Consultation Response from KC,
Strategic Housing

2026/91627 Land at, Dunford Road, Hade Edge, Holmfirth, HD9 2RT

Erection of 22 dwellings (Use Class C3) associated development including access,
landscaping, ancillary infrastructure, and parking.

Responding Ref: SH/26/91627

Proposed Site Layout - Option A (Site A)

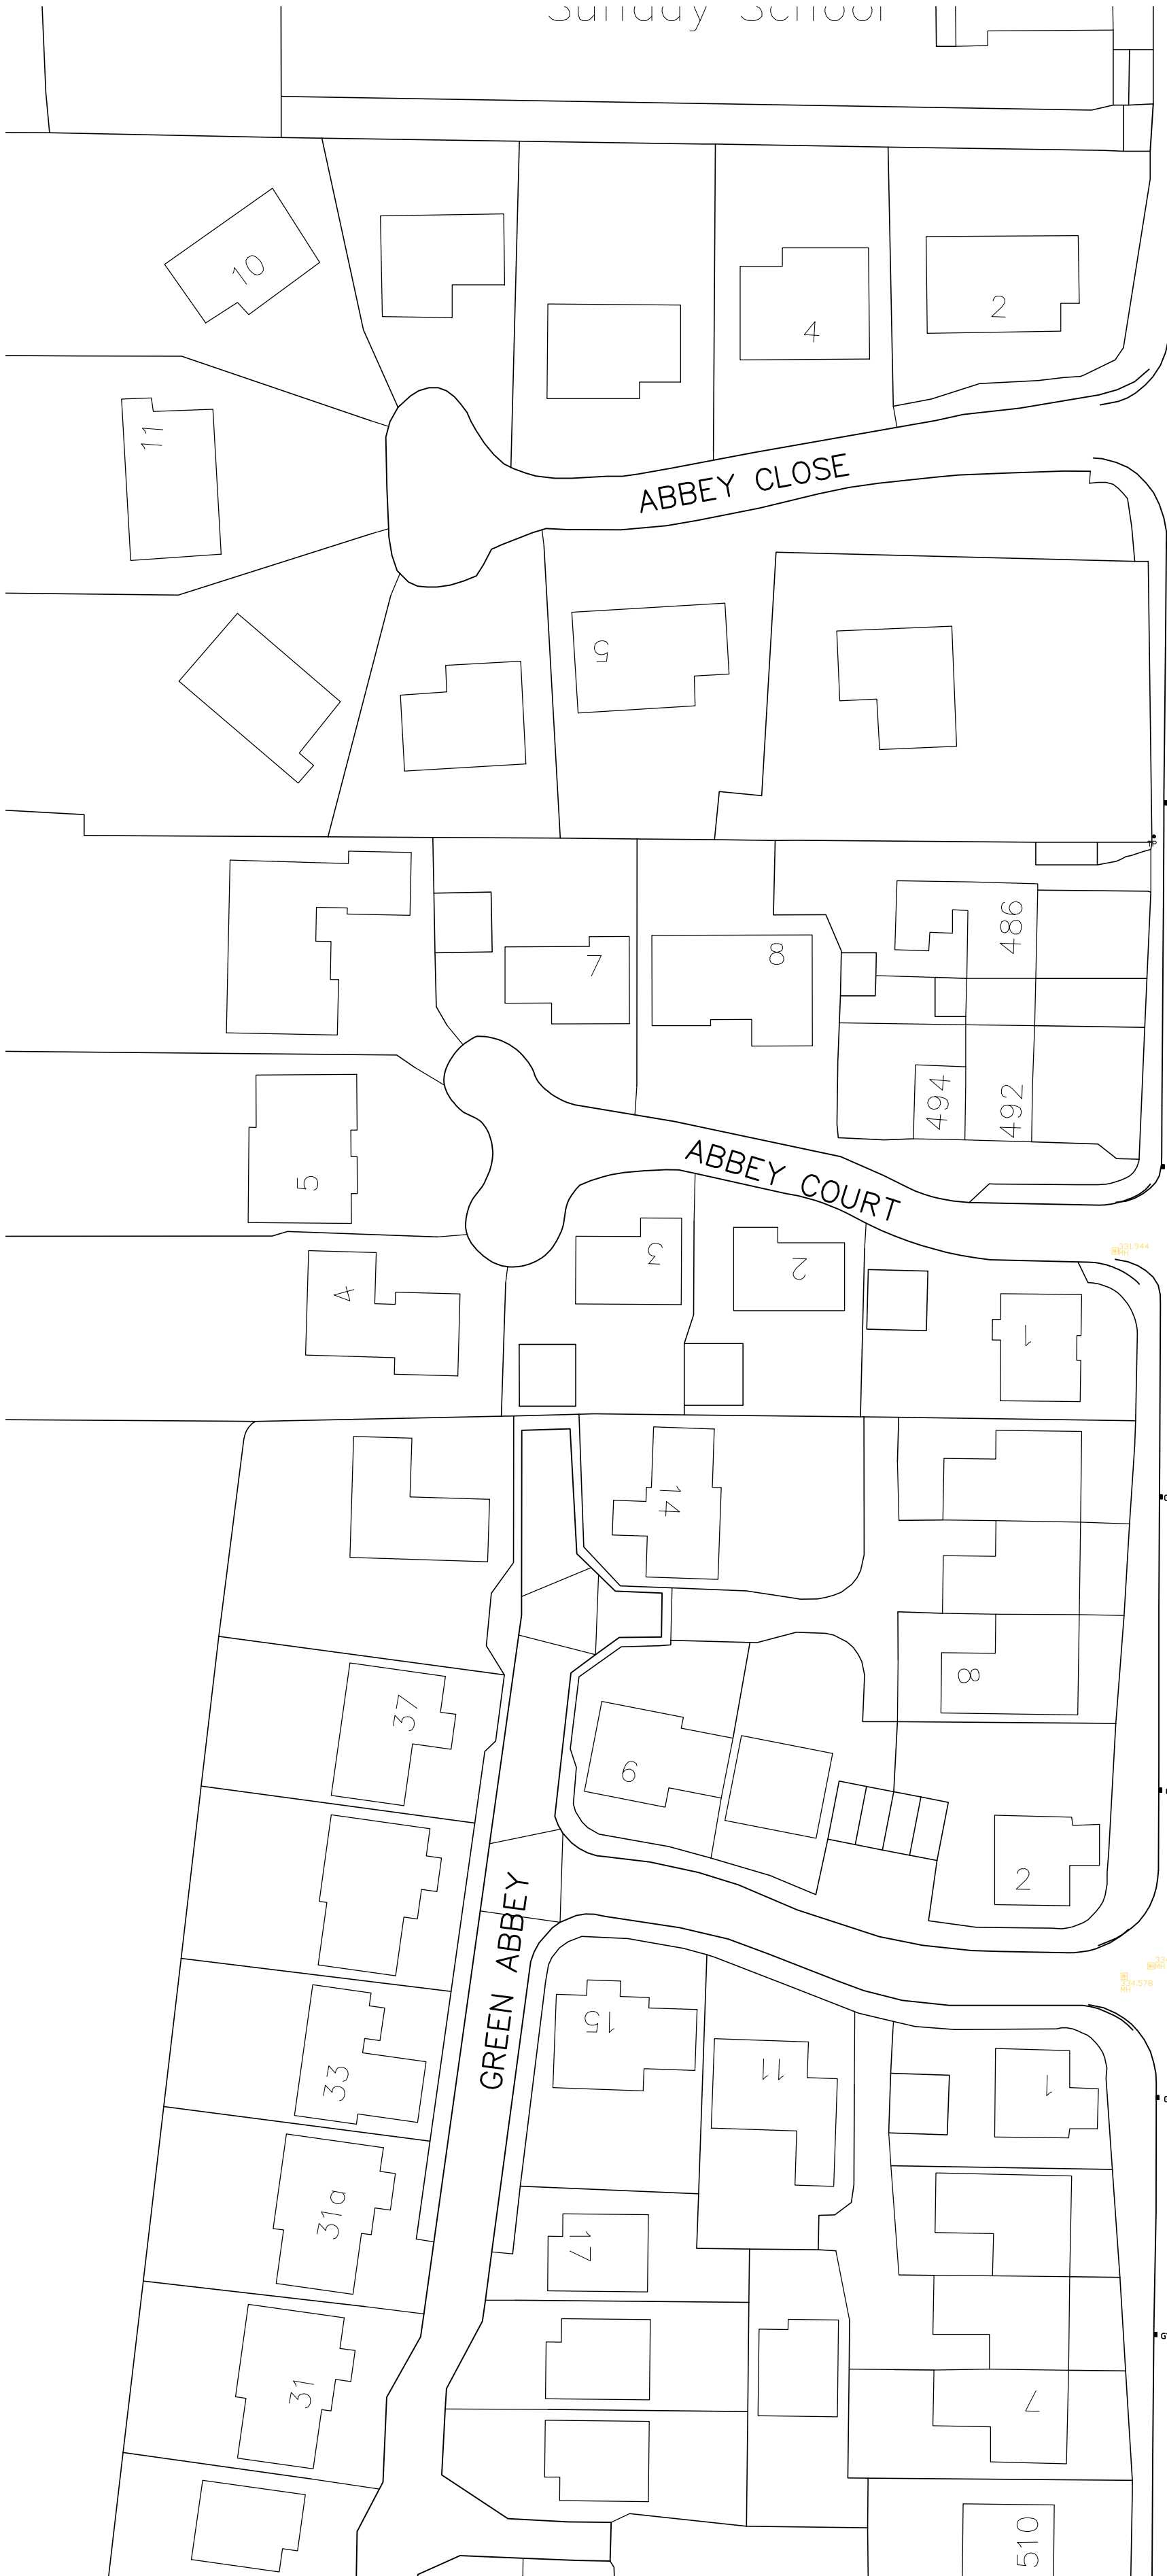
The layout of affordable dwellings should be dispersed throughout the site in smaller clusters, avoiding large groupings of affordable dwellings together that may reinforce social exclusion. Affordable dwellings should be well integrated within the site layout and not located at specific areas at the edges of sites.

The proposed layout shows that the affordable homes are not distributed evenly throughout the development and therefore, Strategic Housing does not support the current proposal.
